DECISION DELEGATED TO HEAD OF PLANNING

Application No: H23-0907-22 **Applicant:** Taas Ltd

Proposal: Details of external gas and electricity boxes, existing and proposed site levels and floor levels, foul and surface water disposal and ground gas protection measures (Conditions 3, 5, 6 & 8 of H23-0897-20)

Location: Rear Of 260 High Road Whaplode Spalding

Project
Proposed Residential Development
Land at High Road, Whaplode
Orig Title
Existing & Proposed Site Plan

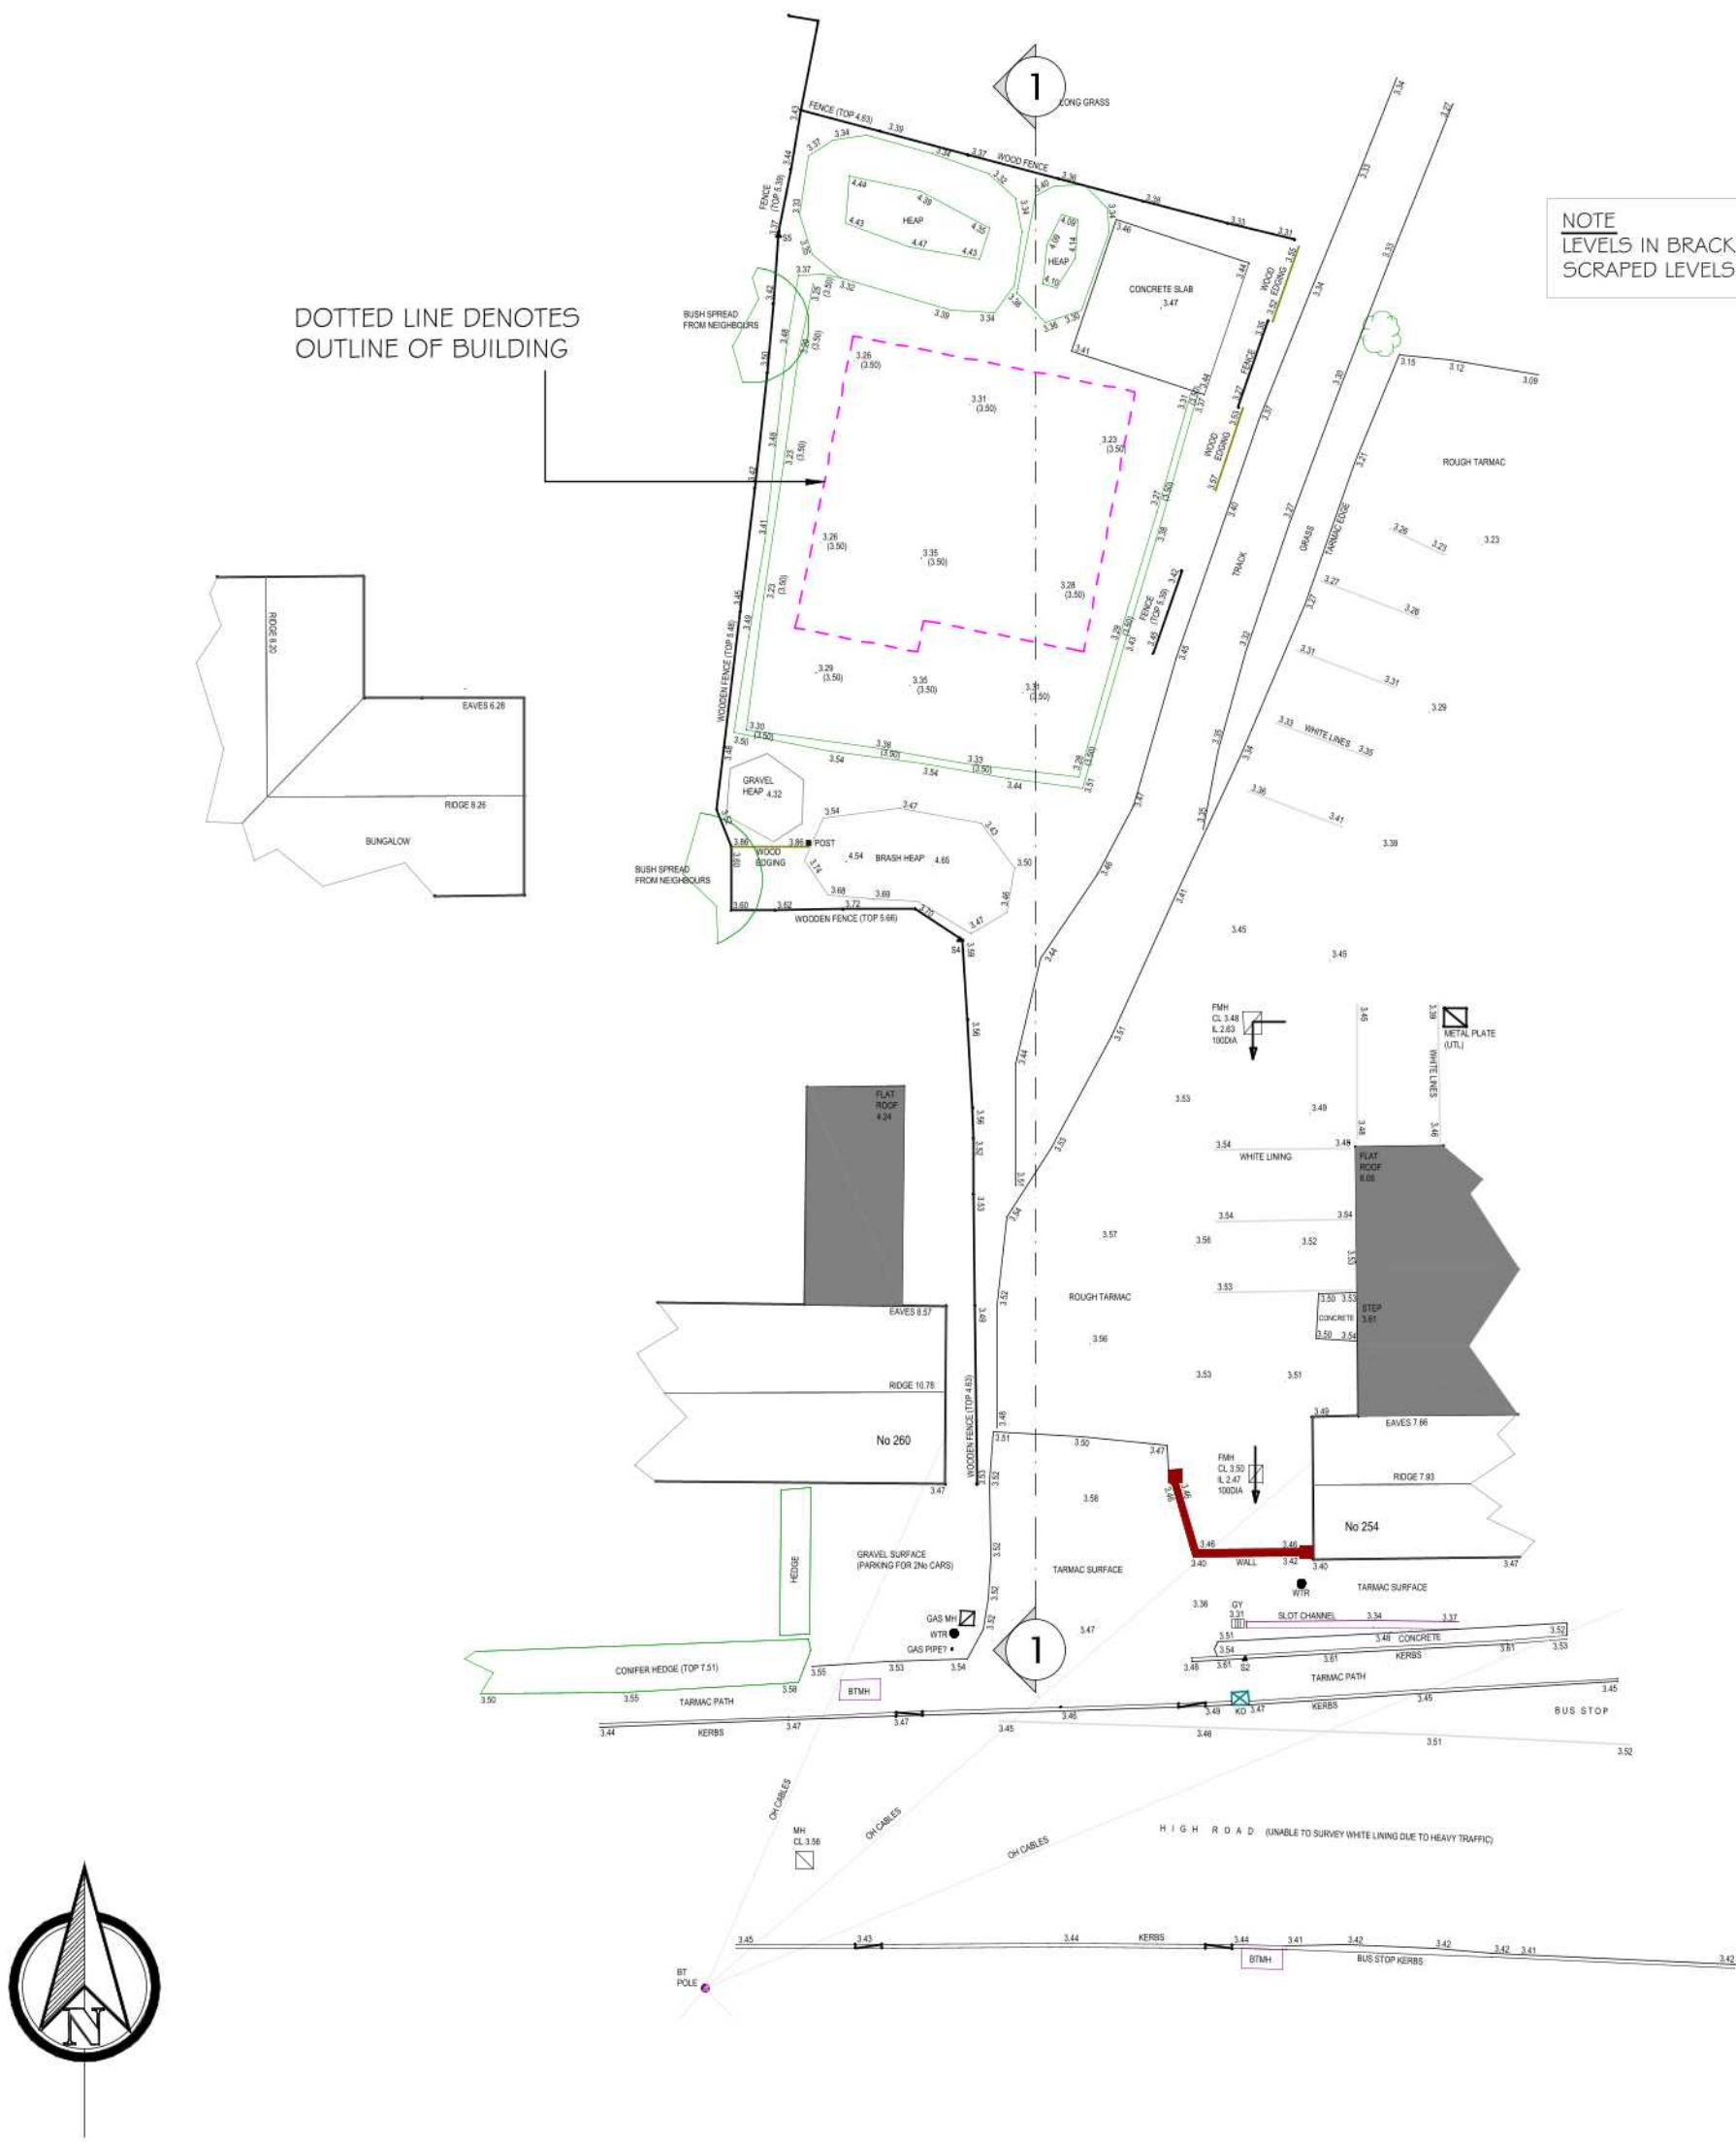
The site section plan shows a very flat site averaging 3.35m AOD to the front and rear. This area has been stripped off topsoil so is likely to be around 3.50m AOD, which would correspond with the proposed finished floor levels being set at 3.80m AOD. The surrounding land beyond the site boundary is also around 3.50mAOD. Due to the separation distances, and a 1.8 metre high fence bordering this single storey dwelling, there is not considered to be a material overlooking, overbearing or overshadowing impact from the proposed levels.

DRAWING TITLE:
Proposed Bungalow To Rear
of At 260 High St
Whaplode, Lincs. PE12 6TG

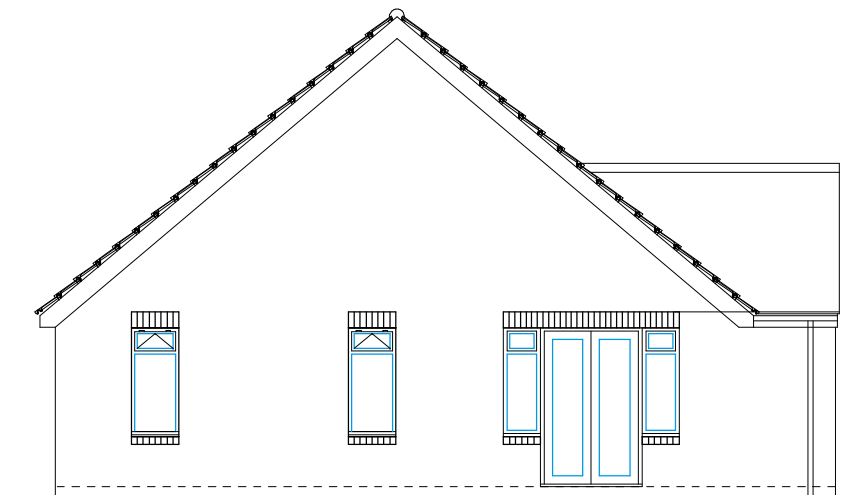
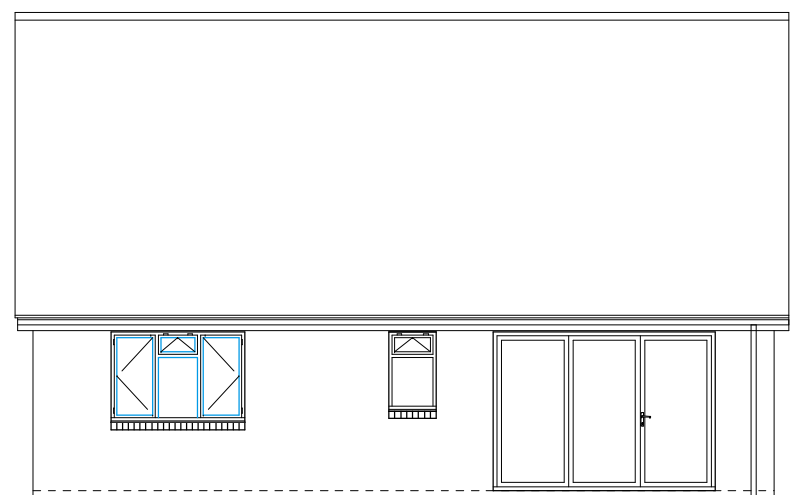
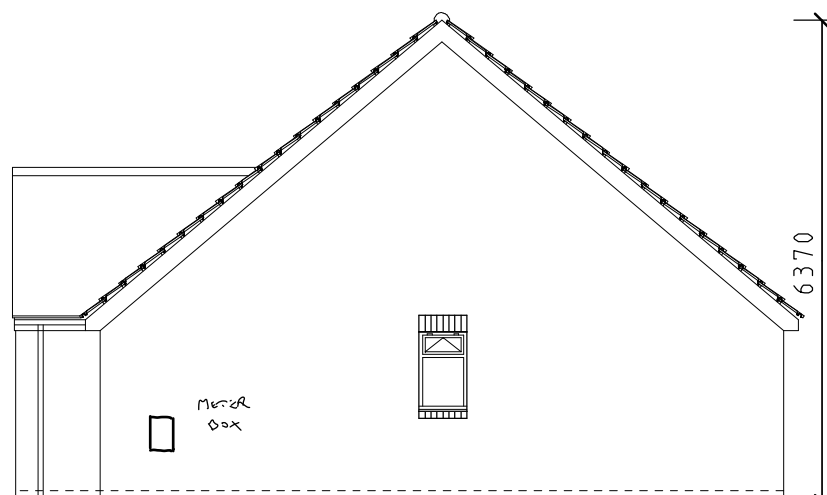
The gas and electricity boxes will be sited on the east facing side elevation close to the south facing frontage. The location is not visually prominent and allows for easy access.

Condition 3 of H23-0897-20 has now been addressed.

Section 1 - 1 Through Dwelling (scale 1:50)

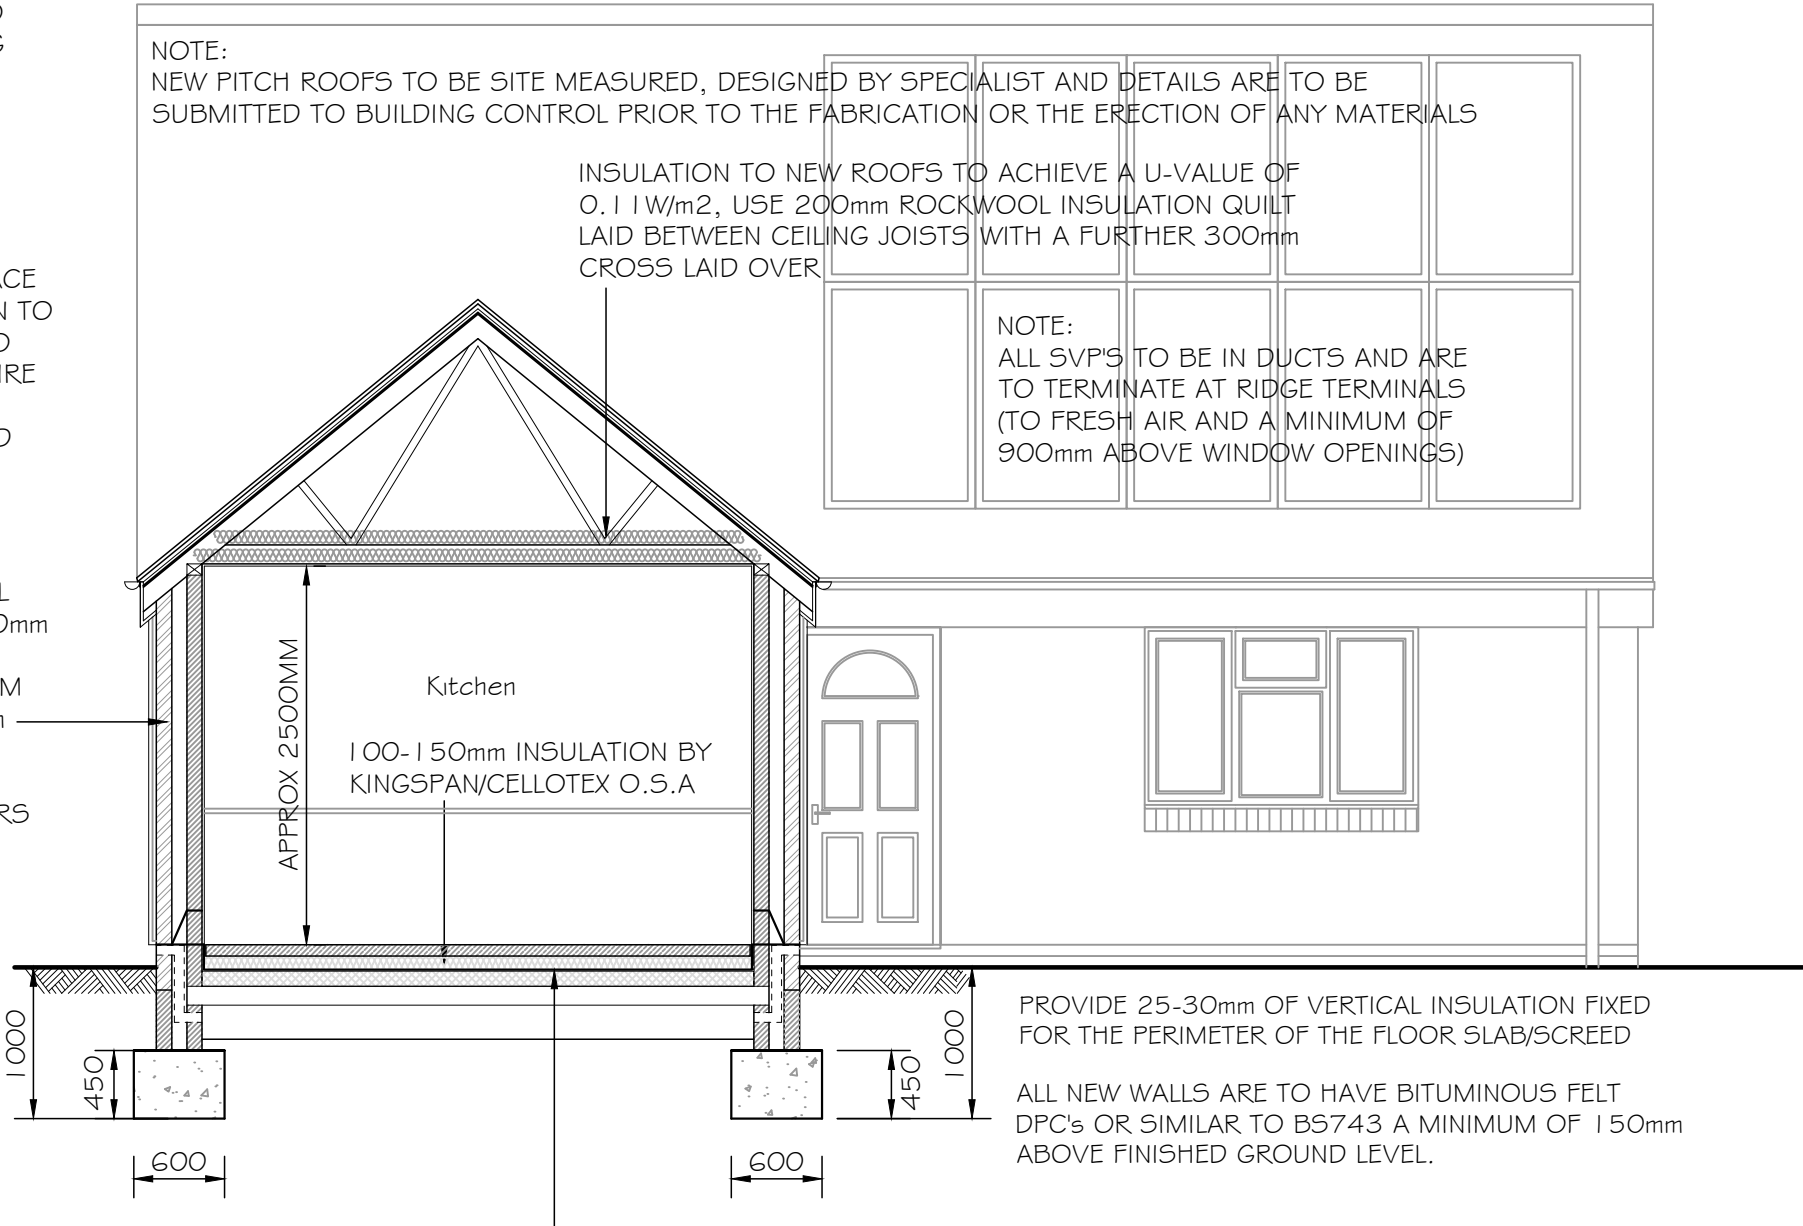
A Radar 1200g Radon barrier has been installed below the finished floor level.

Condition 8 part i of H23-0897-20 has now been addressed.
